EPC STORMWATER REVIEW COMMENTS
IN ORANGE BOXES WITH BLACK TEXT

GRADING AND EROSION CONTROL PLAN CHECKLIST

PPR2344

GRADING & EROSION CONTROL PLAN

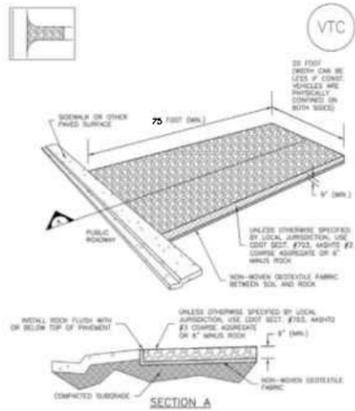
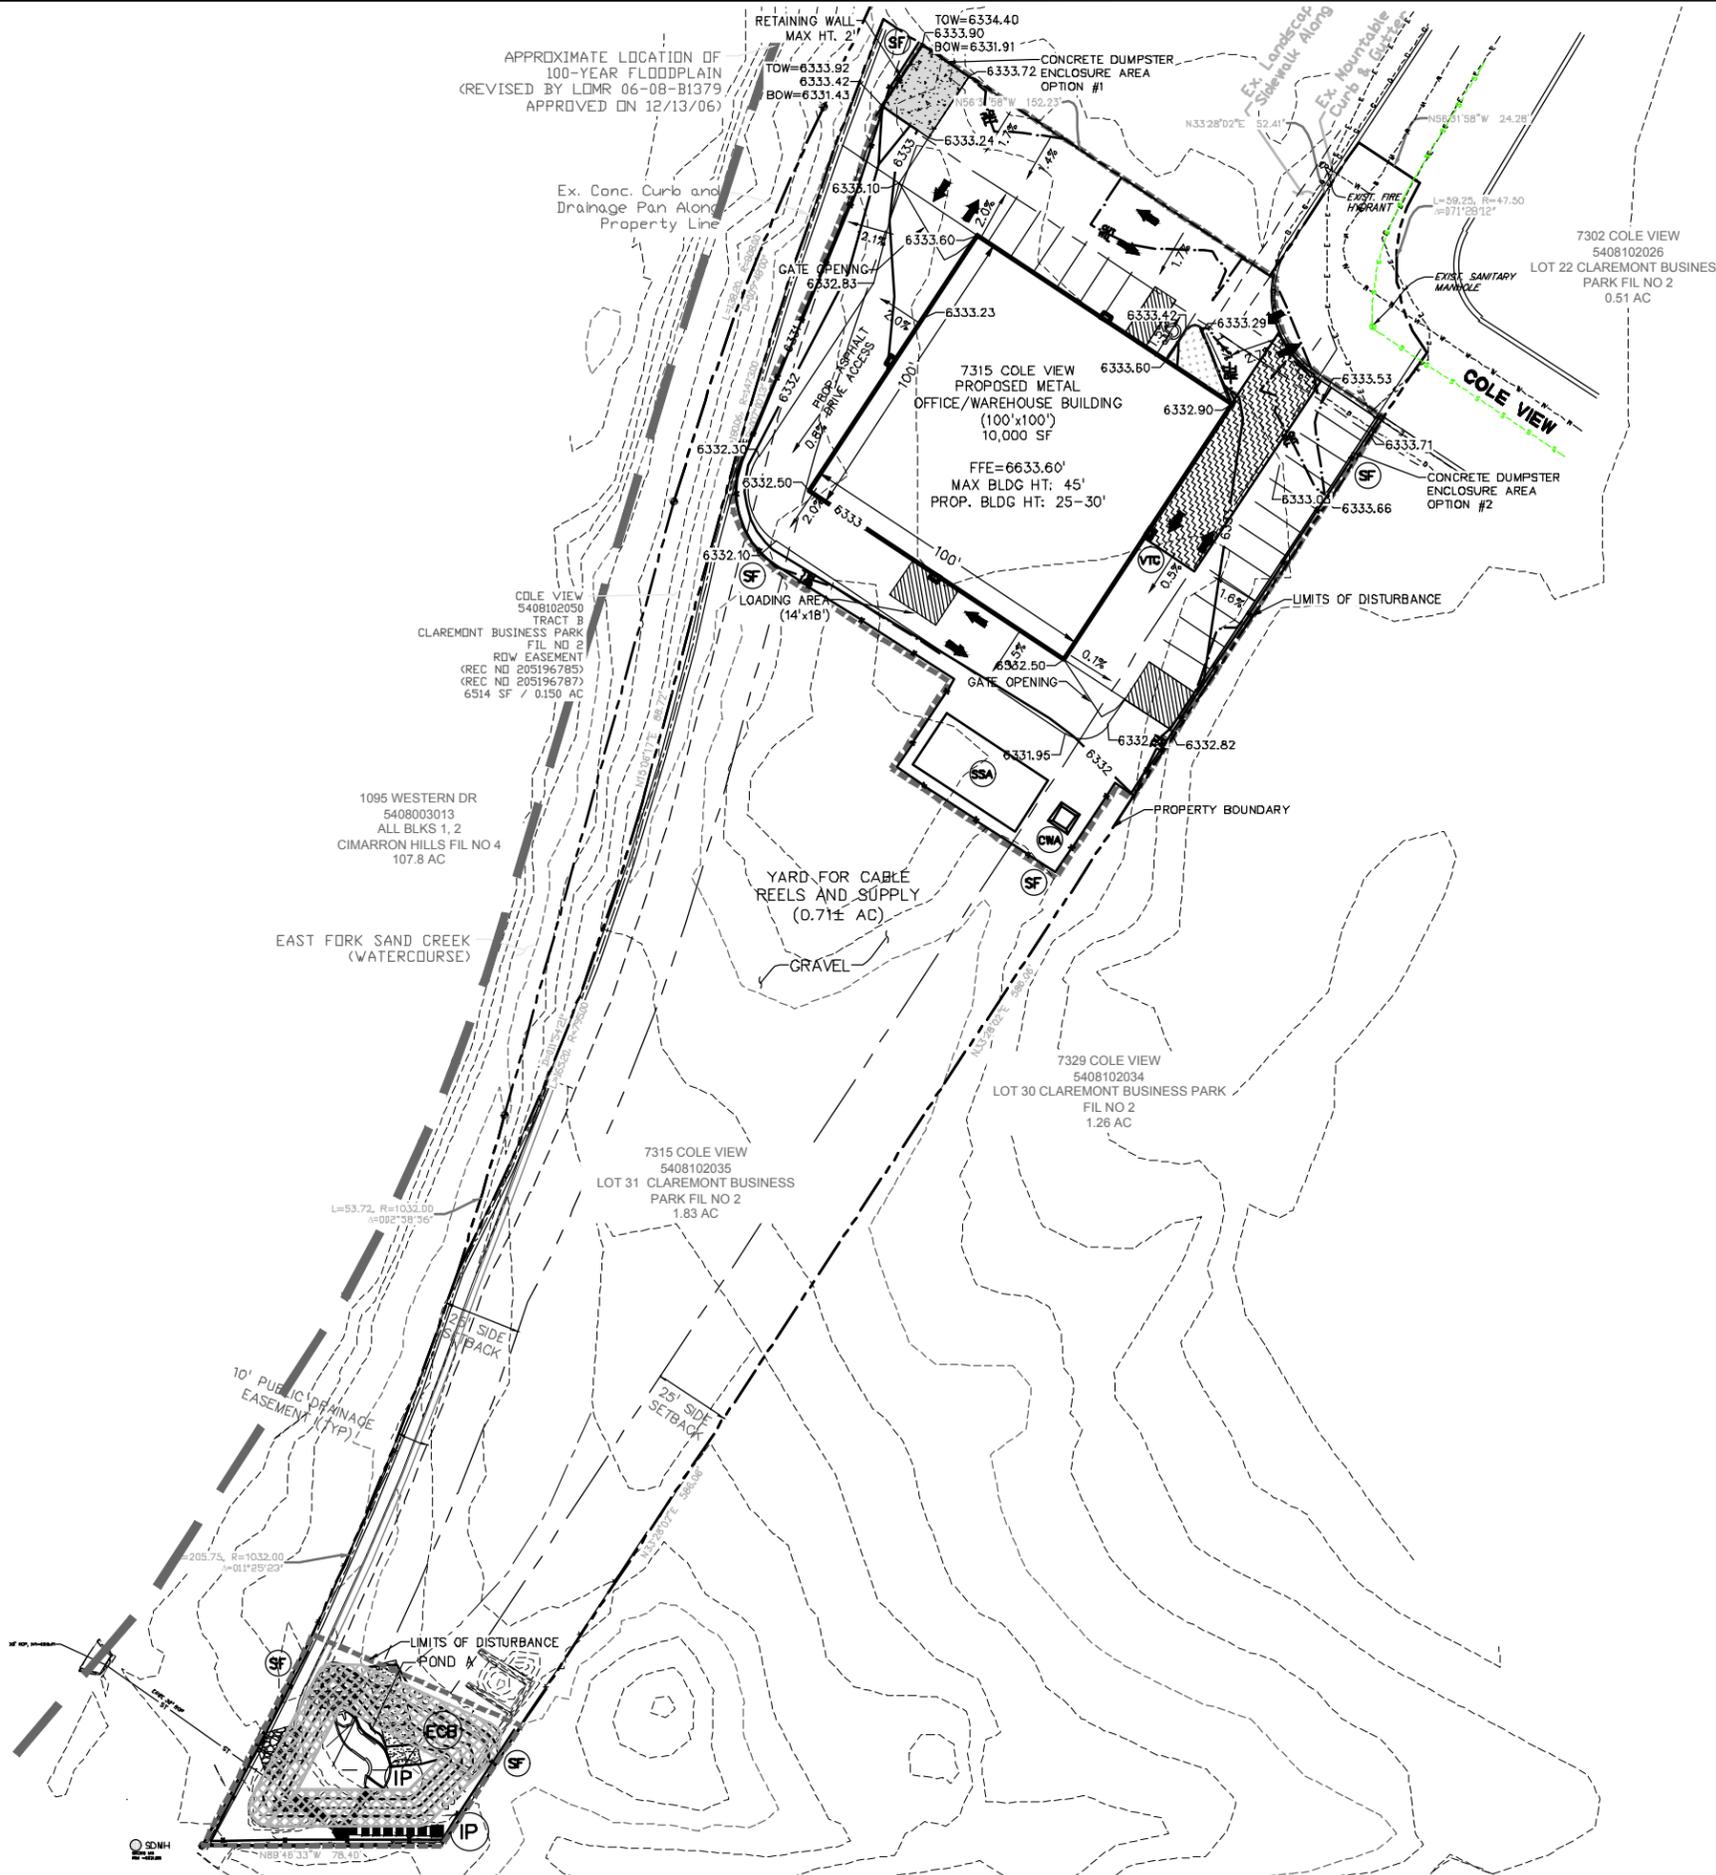
N/A? Or show on plans where the diversion, pump, and discharge locations are
